Recommendation Report

Application No. AW/49/11.

Subject: AW/49/11 - 11 Willowhale Avenue, Aldwick

Two storey residential extension
11 Willowhale Avenue Aldwick PO21 4AU

Proposed Ground Floor Plan

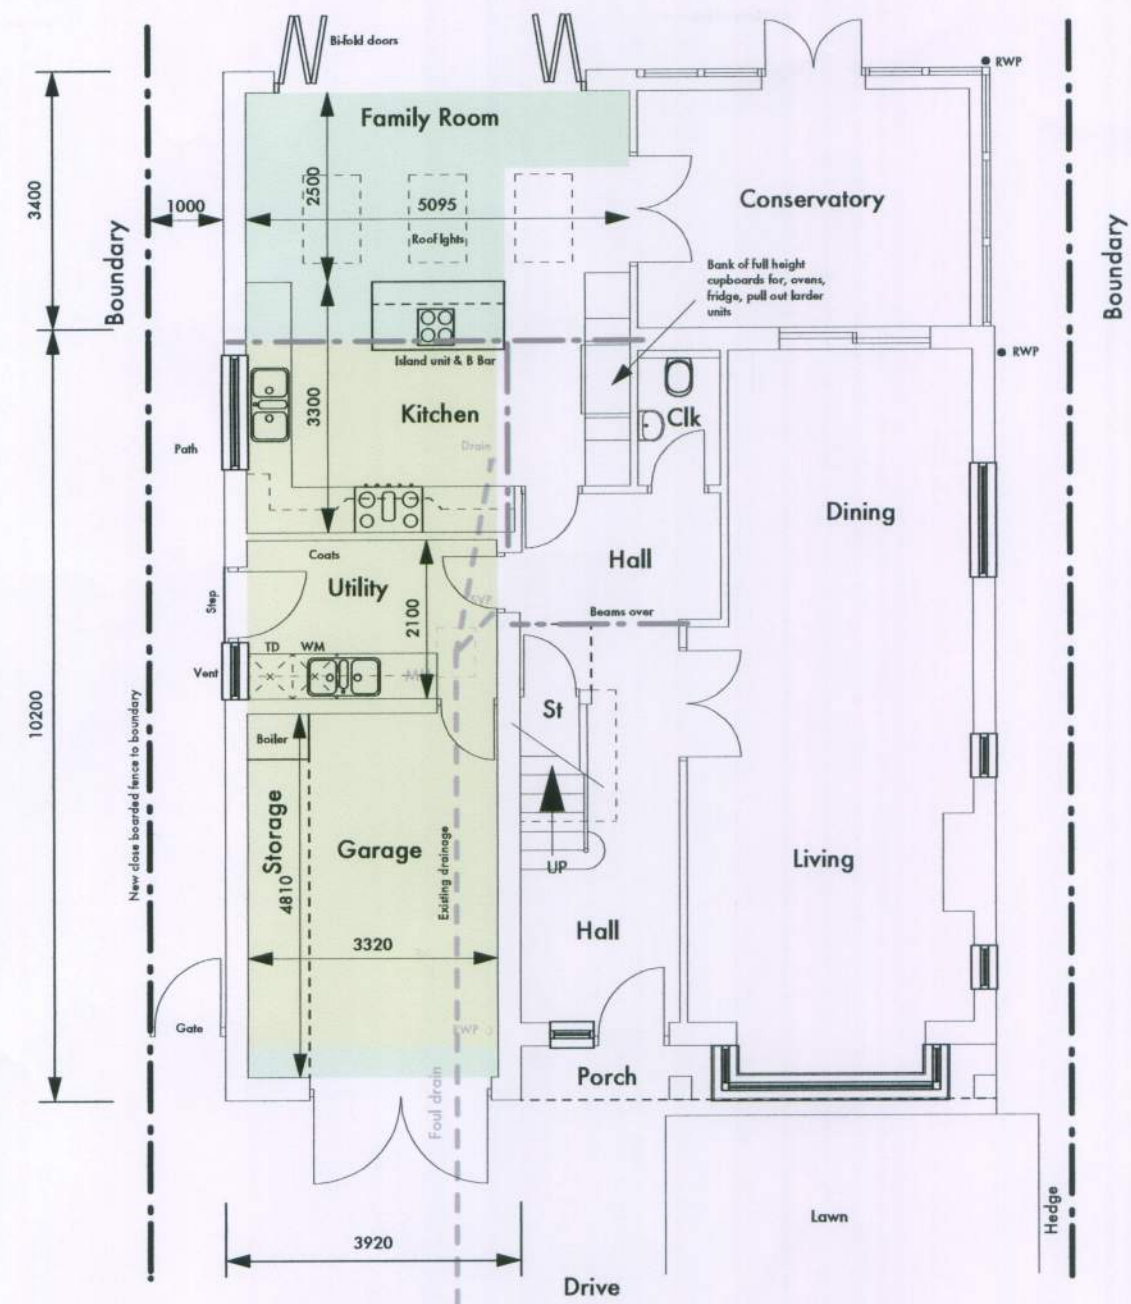
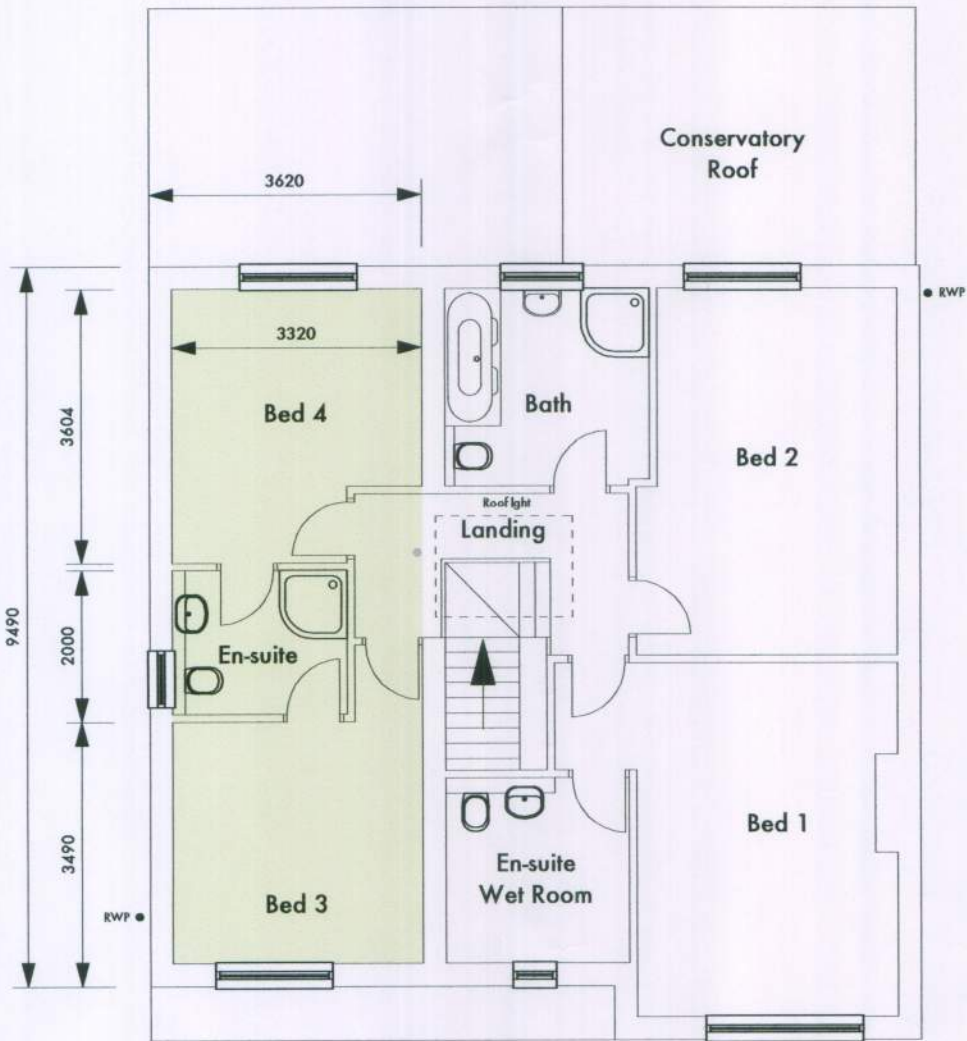
- 1) I have moved the line of the first floor front extension back to that of the existing and adjoining properties, this should now not be a problem.
- 2) I have kept the ground floor front building line in line with the existing garage, again this should now not be a problem.
- 3) I have updated the site plans to reflect what is approved at No 15 and what is built at No 9, this shows the true relationship between all 3 properties.

Site Plan
Scale 1 : 250

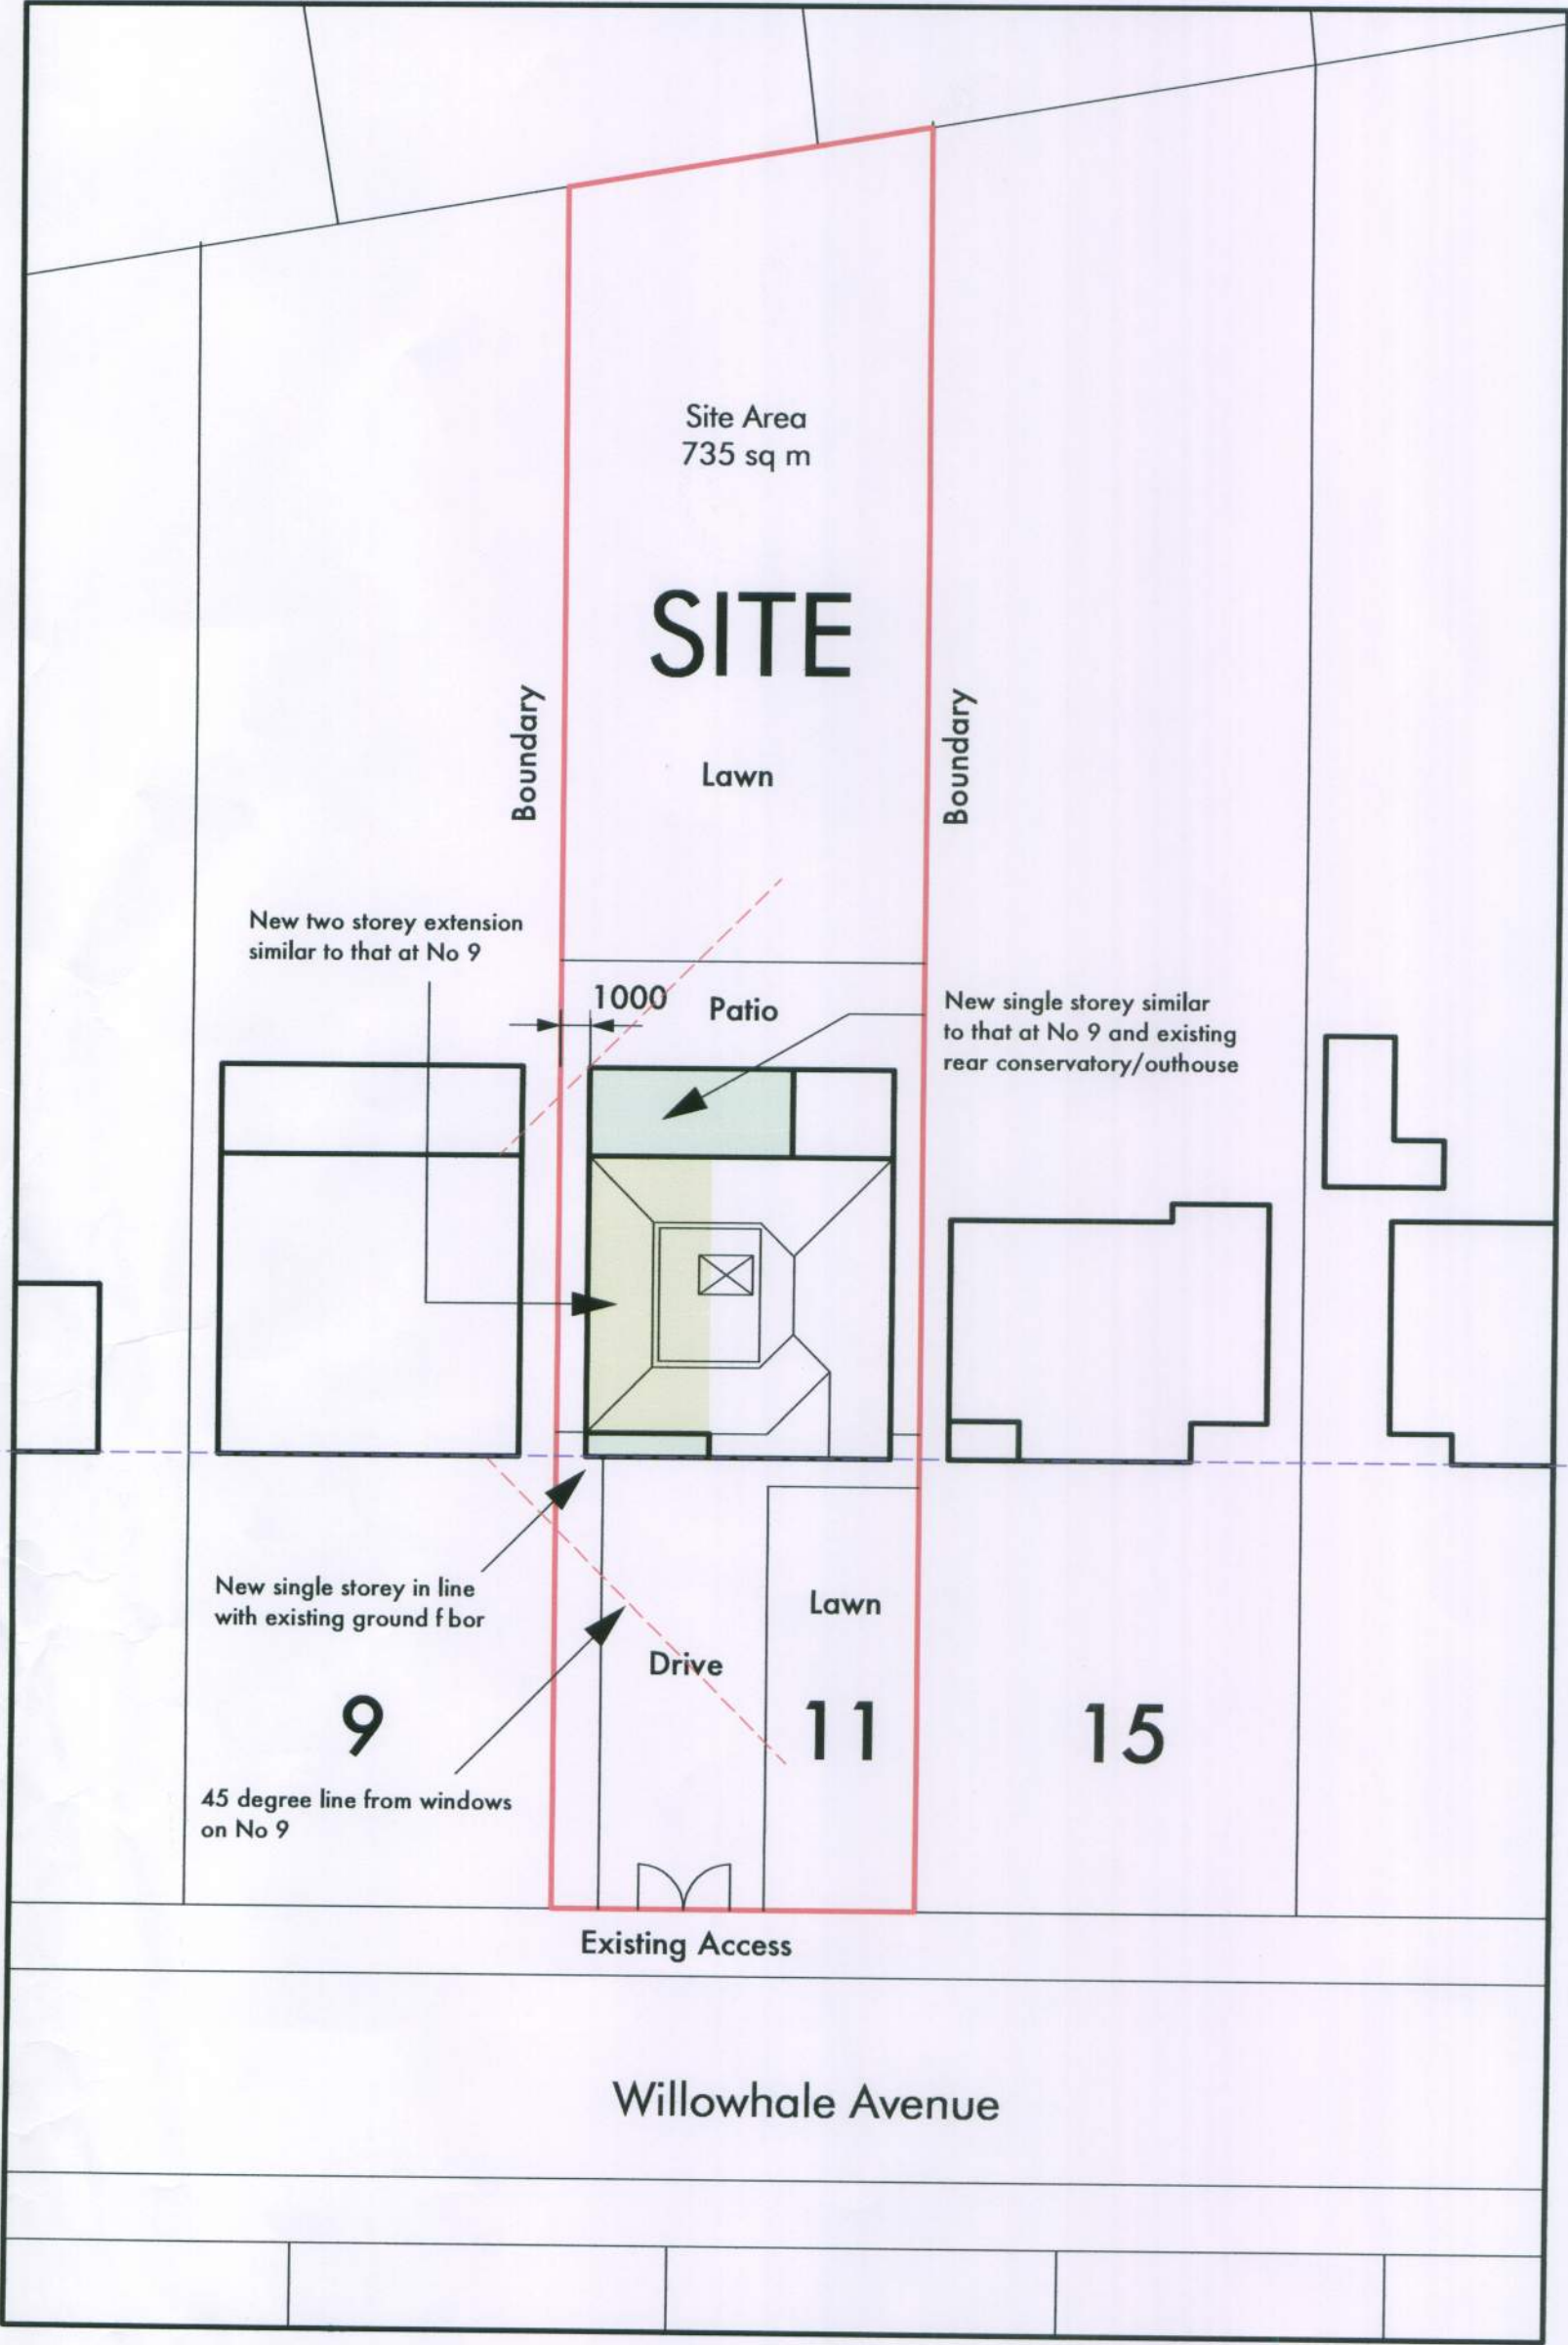
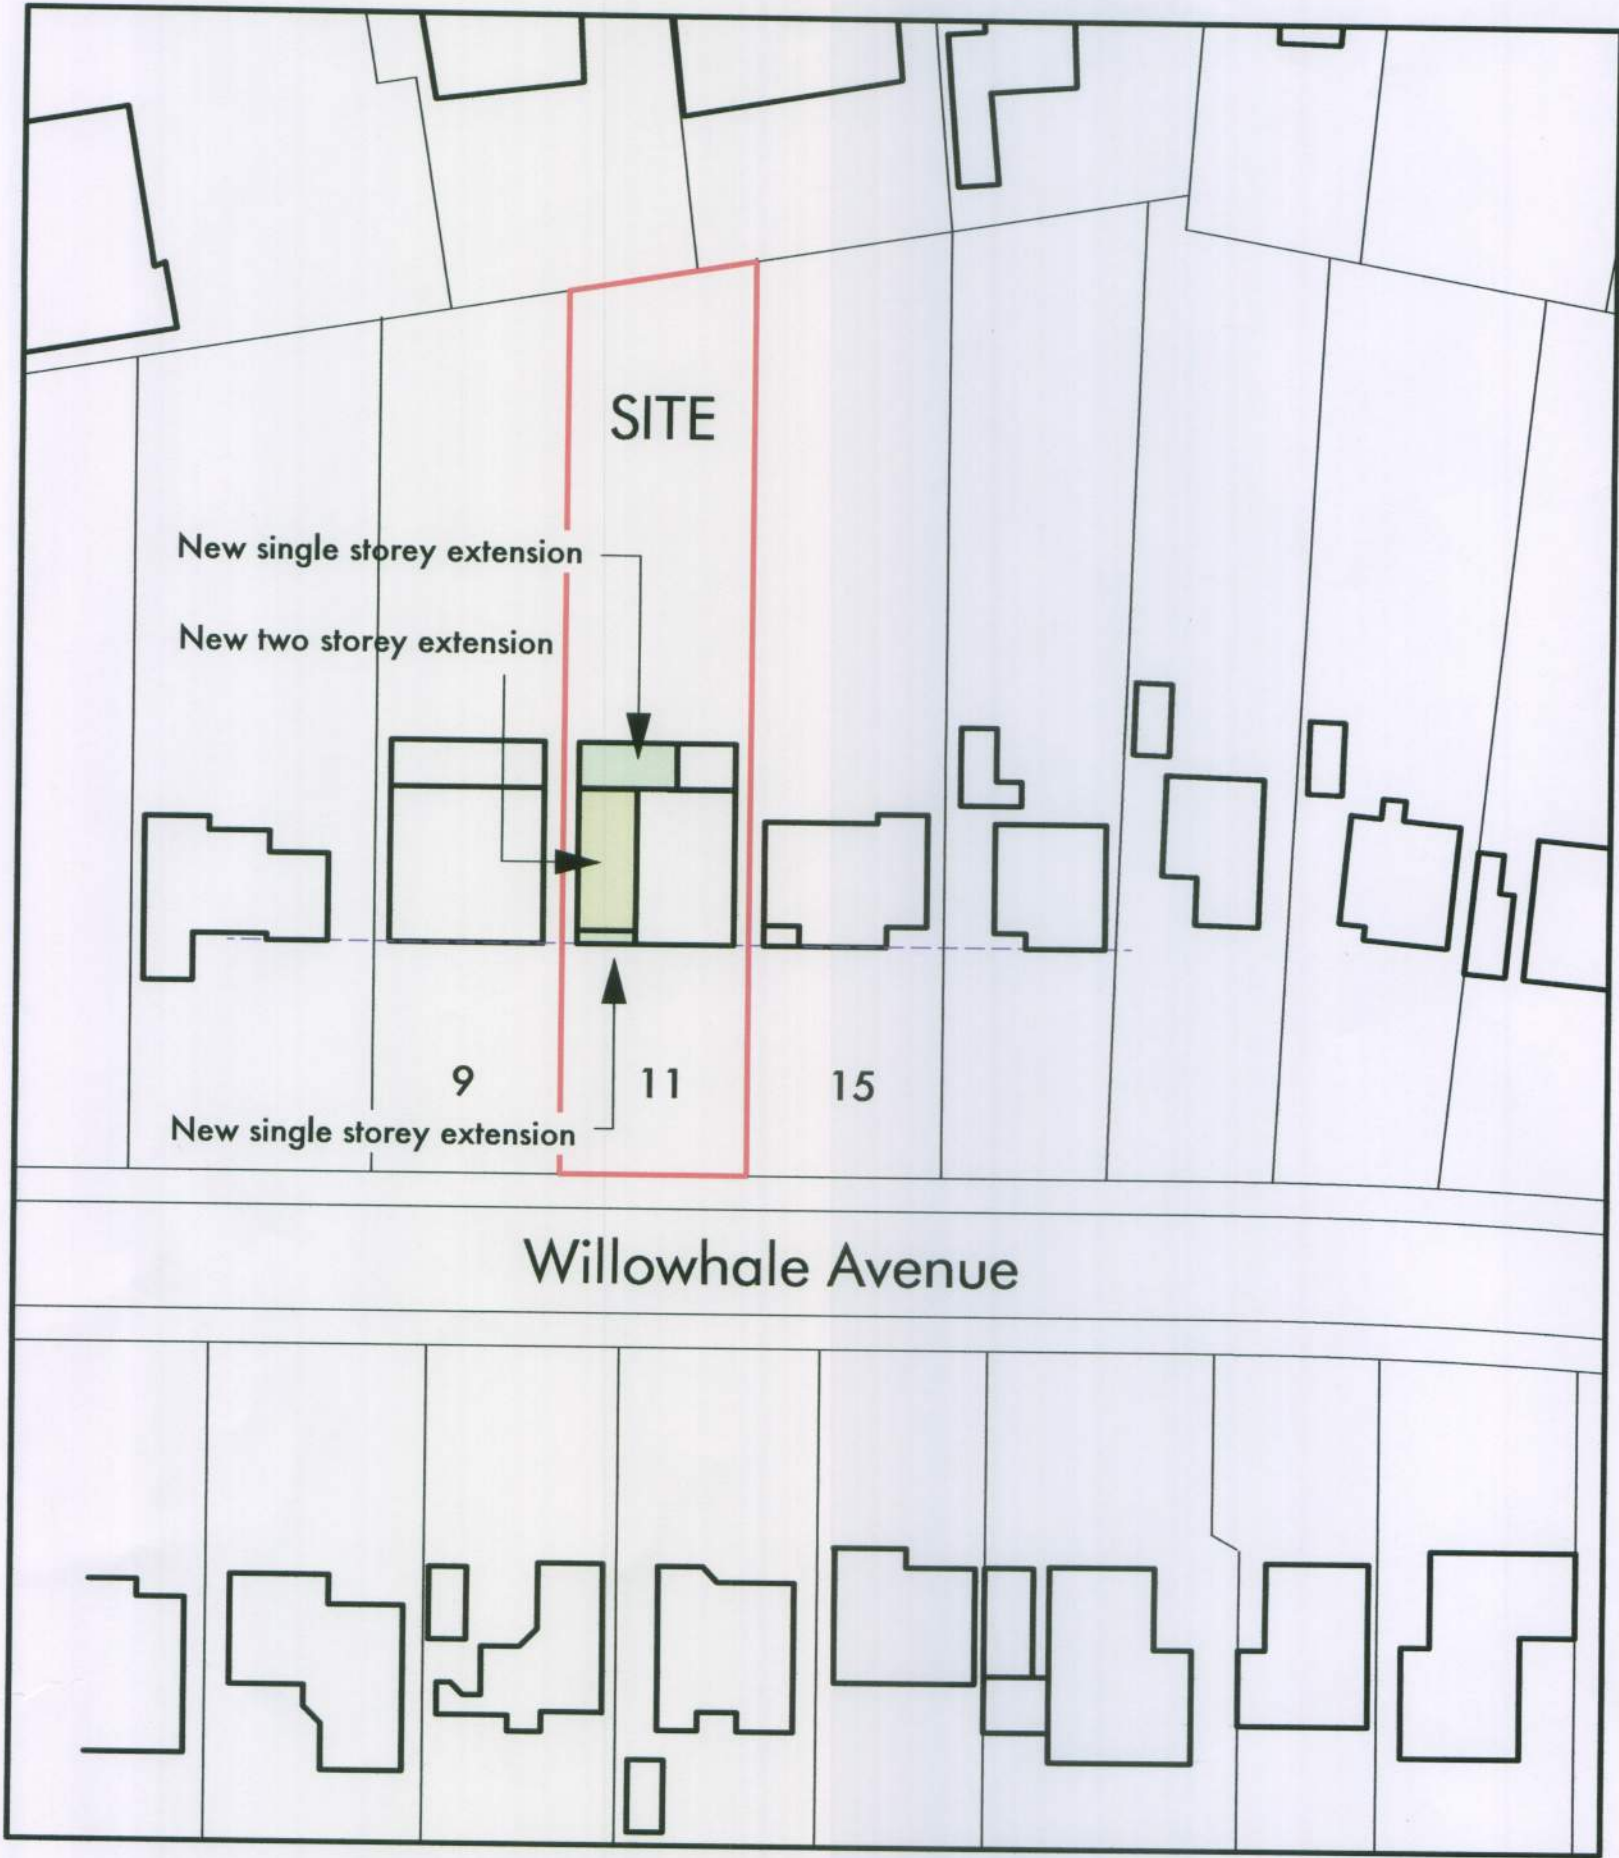
Sorry, please find attached amended Location and Site Plans.
